From: Amanda Scholes on behalf of Planning.Responses
Sent: 15 July 2020 08:51
To: Planning Scanning
Subject: FW: Application AL/23/20/HH - amended plans

AL/23/20/HH

Hi
AL/23/20/HH at Innisfree , Belle Mead Close

project	26 Belle Meade Close, Woodgate, PO20 3YD
detail	Proposed floor plans, elevations and perspectives
drawn	JJH checked MSC
date	JUNE 2020 status
a1 scale	a3 scale
as shown	8901 02 rev A

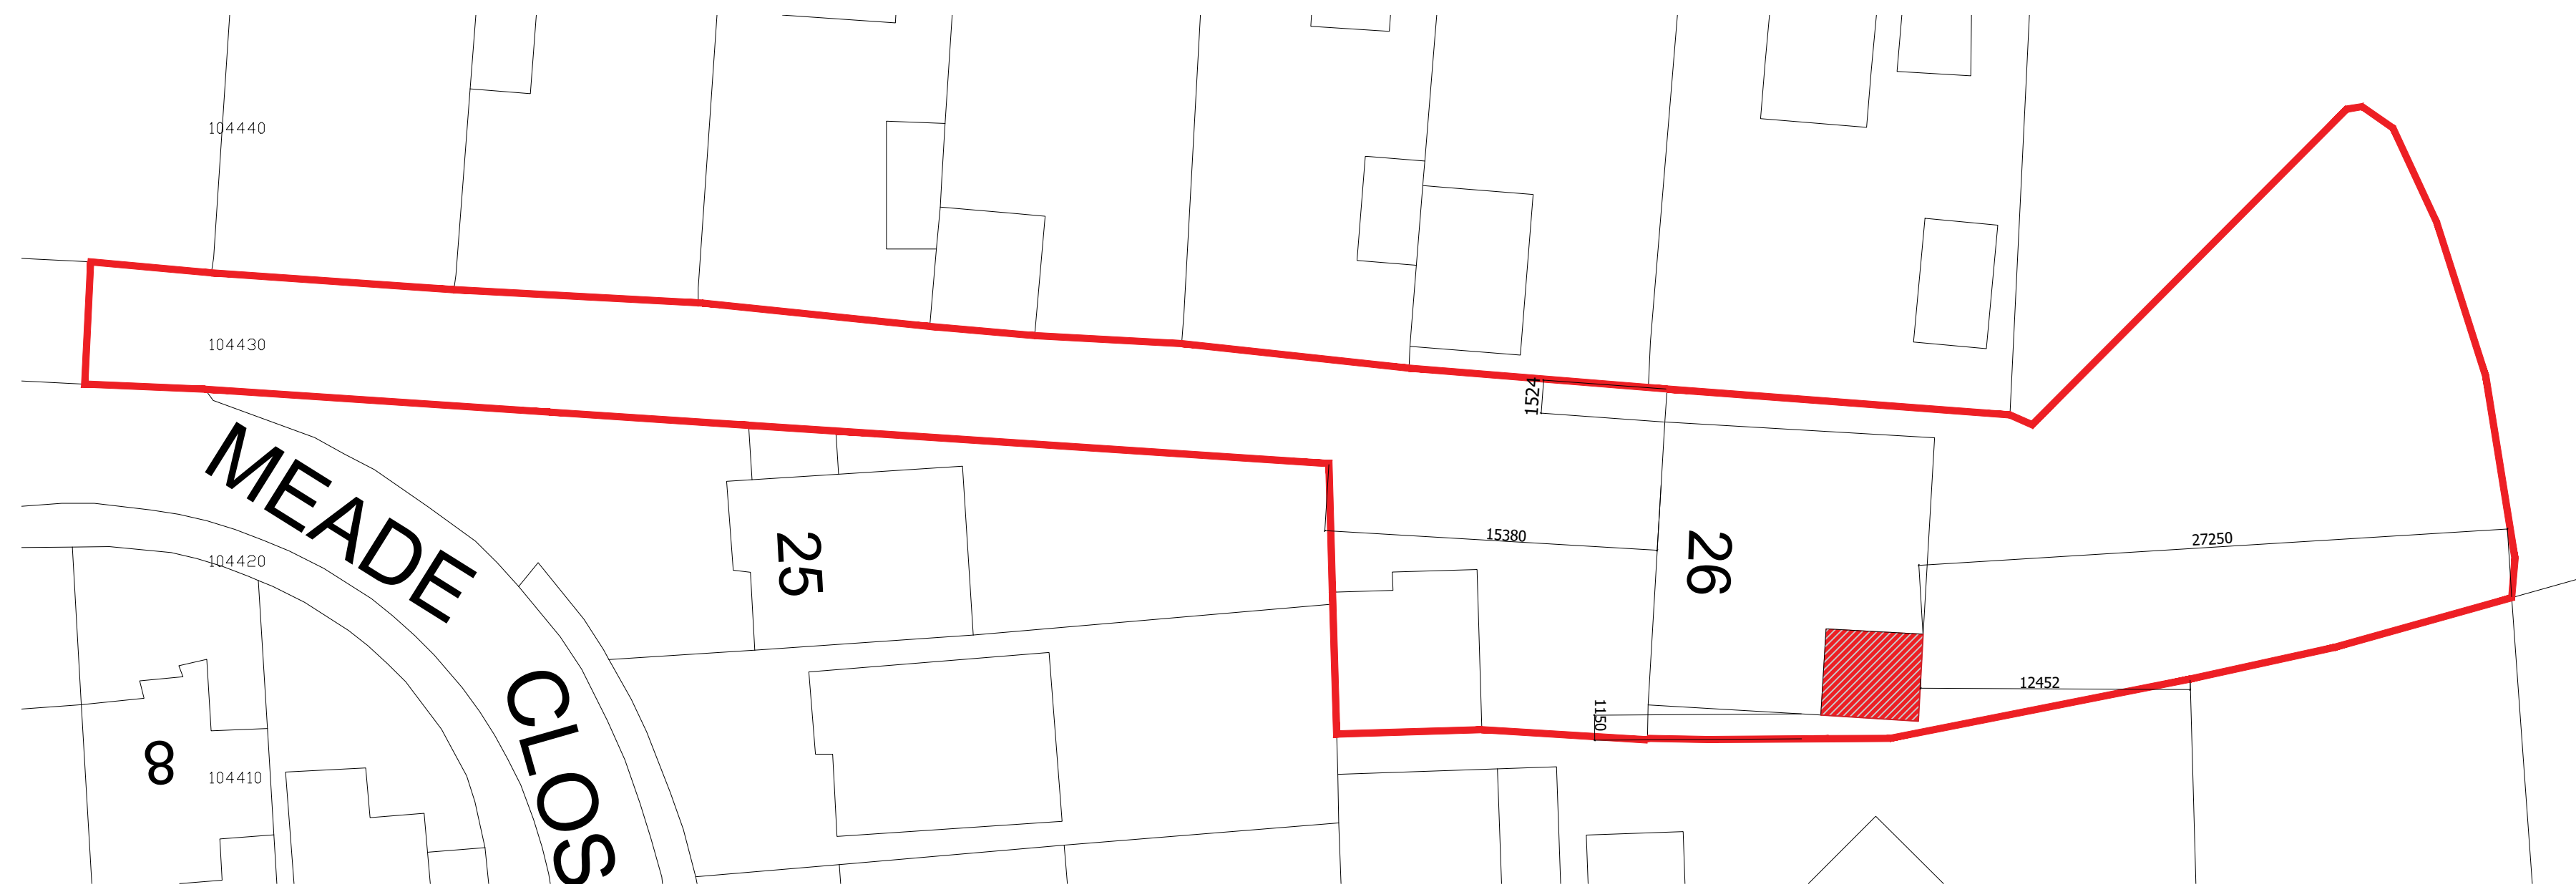
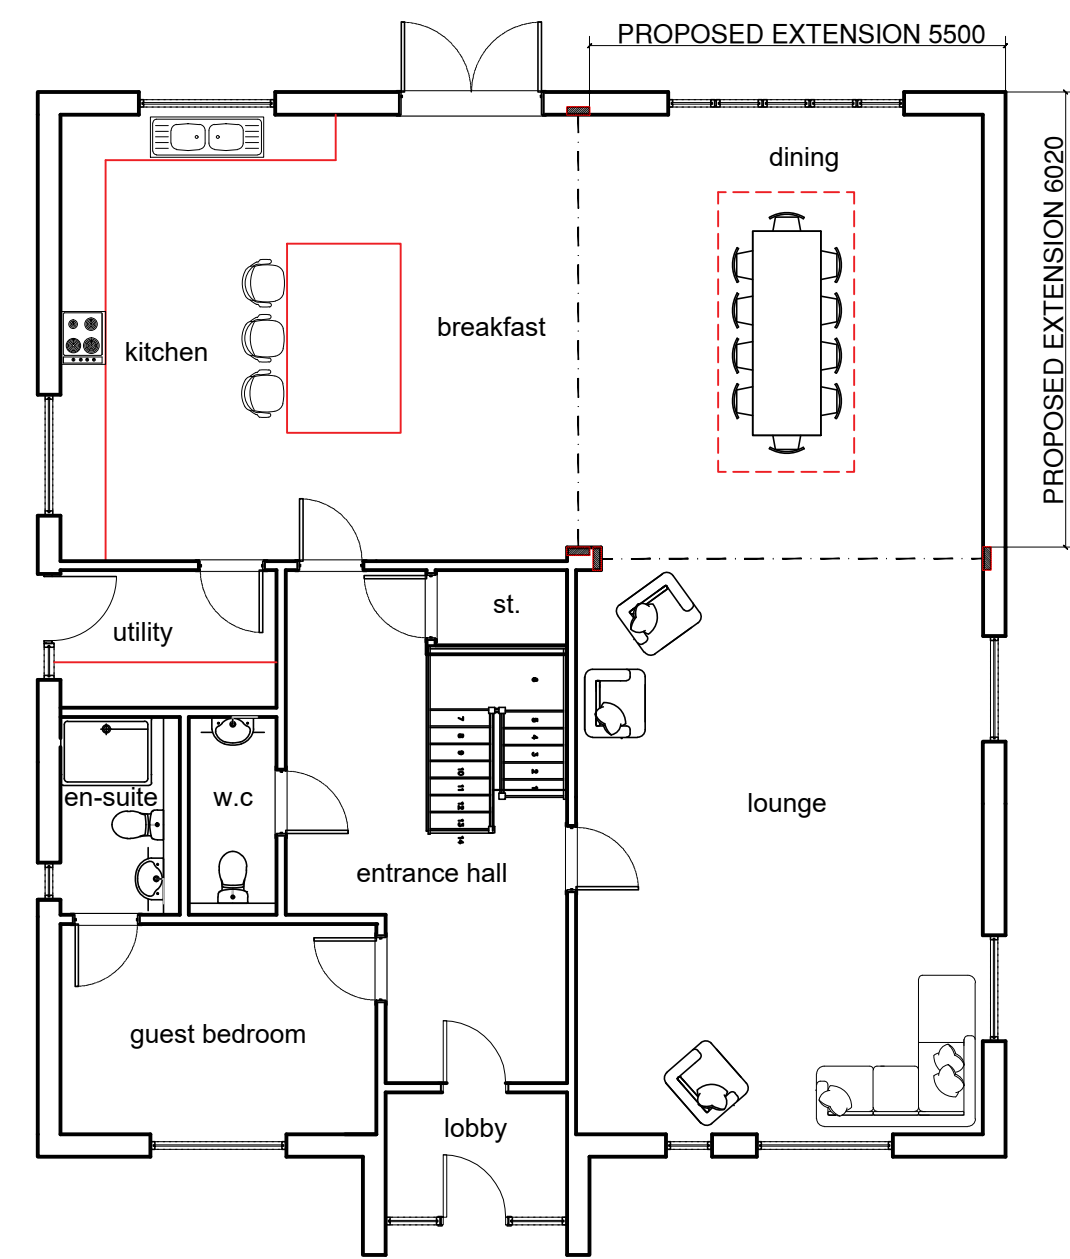
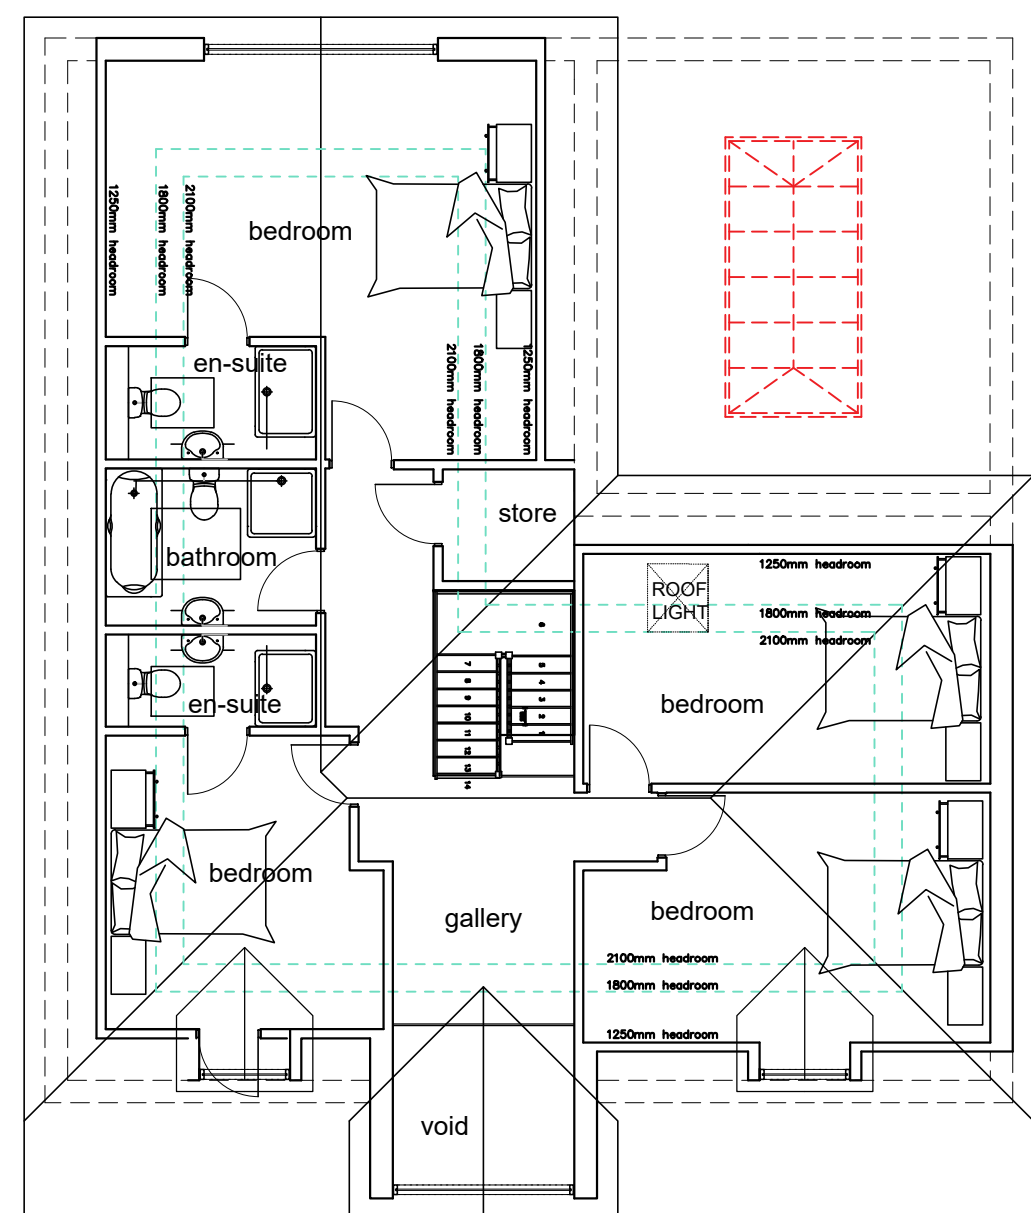
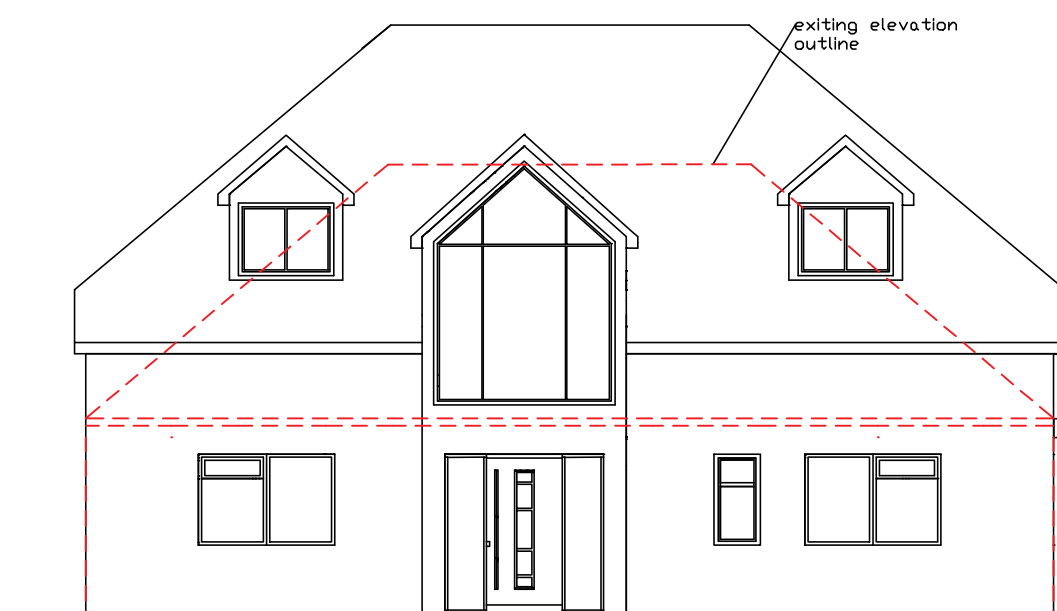
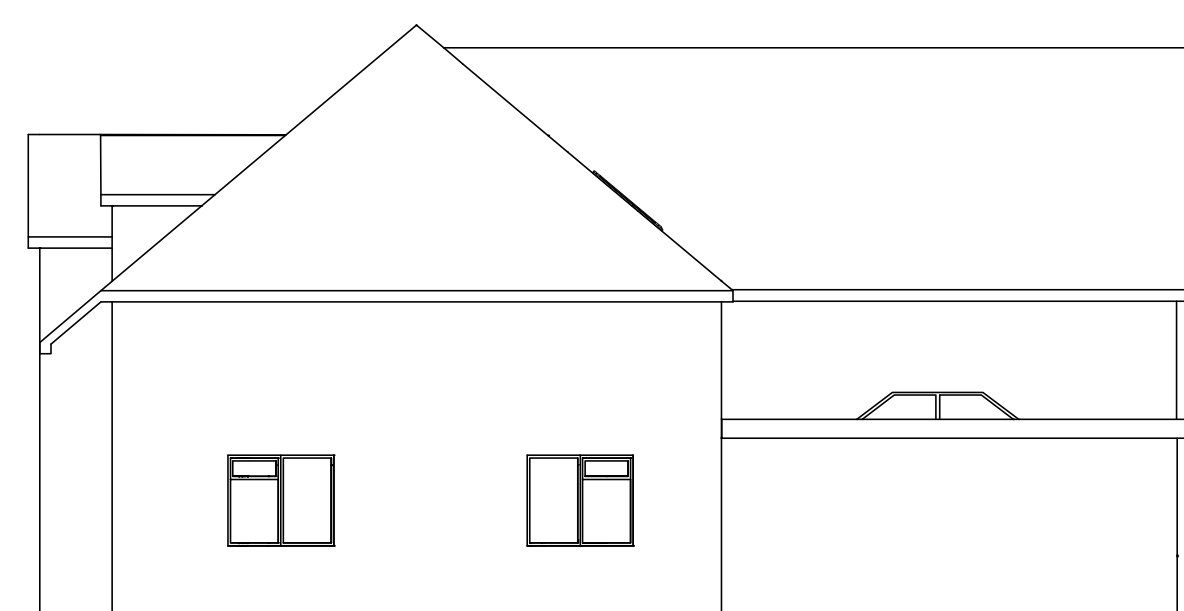
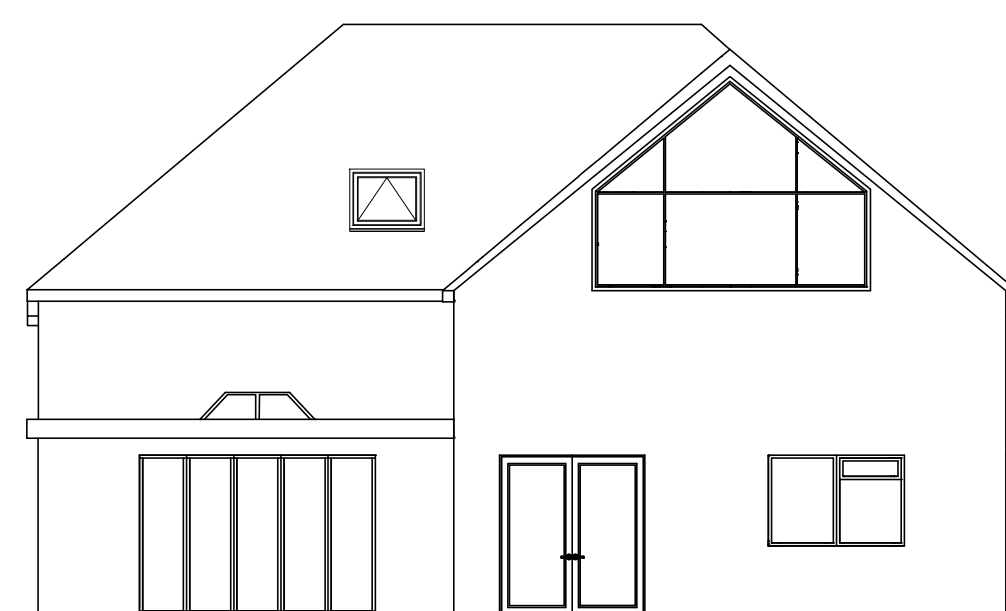
I believe this is exactly my issue, the proposal will be significantly overbearing against our property, the close proximity will be visually impacting from almost every aspect and room from our property including being oppressively visible from the gardens.

As I have tried to express the close proximity of the property will result in significant loss of sunlight and will impinge upon our privacy - even with the removal of the dormer window and the outlook from our property will be dominated by the height increase.

>> I have noted that the a set of substitution plans have been submitted for AL/23/20/HH that have done the minimum to address some of my objections to the application by removing the closest dormer window to our property. However there is no significant material changes to either the large east facing window or the development height both of which will dominate and overshadow our property restricting our right to privacy and continued enjoyment of our property.
